NORTH LINCOLNSHIRE COUNCIL

LOCAL IMPACT REPORT

**SUBJECT: APPLICATION FOR AN ORDER GRANTING DEVELOPMENT
CONSENT FOR THE VIKING CCS PIPELINE**

Planning Inspectorate's Reference: EN070008

FIGURE TITLE
Appendix A (1 of 6)
Biodiversity Net Gain
Baseline Habitats
Immingham

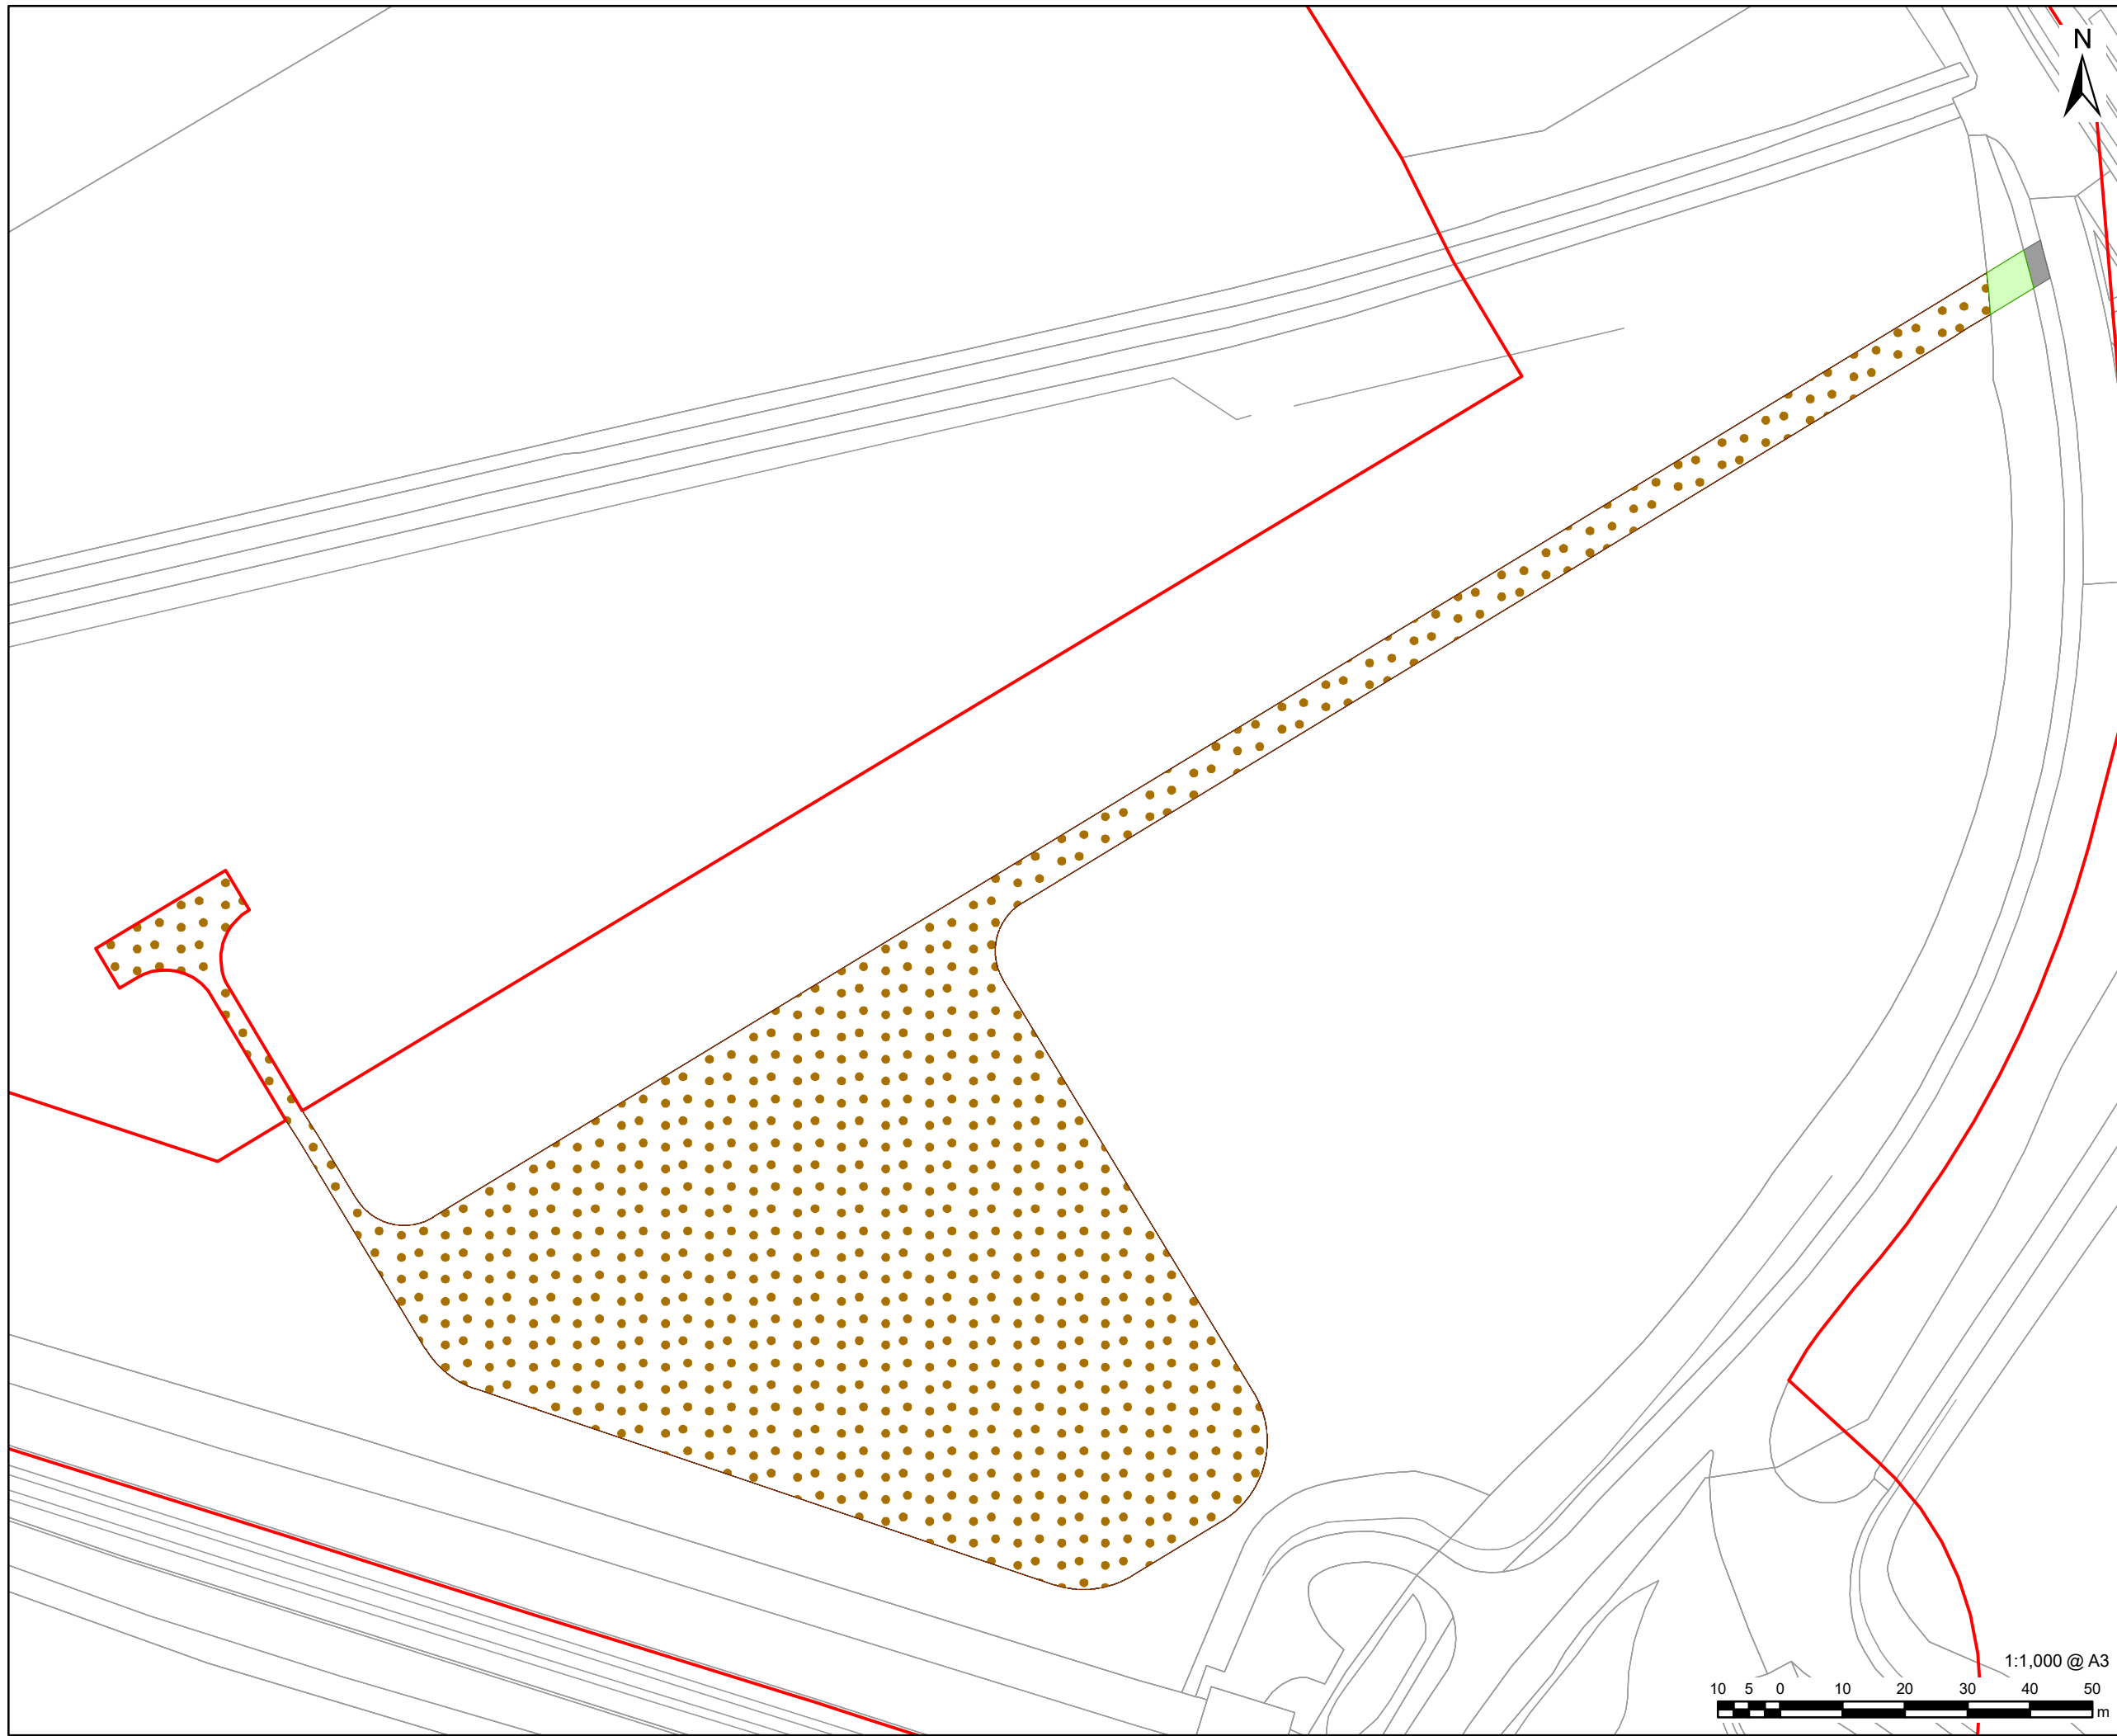
- 8.12 The commitment to providing Biodiversity Net Gain is welcomed. However, it appears that the approach to the Immingham Facility requires further explanation. The VPI Carbon Capture (PA/2023/421) baseline survey shows the area as scrub and grassland. However, the Viking CCS baseline shows bare ground. This may reflect an assumption that the VPI development will have taken place in advance of Viking CCS and will have addressed habitat losses, but this is not clear.
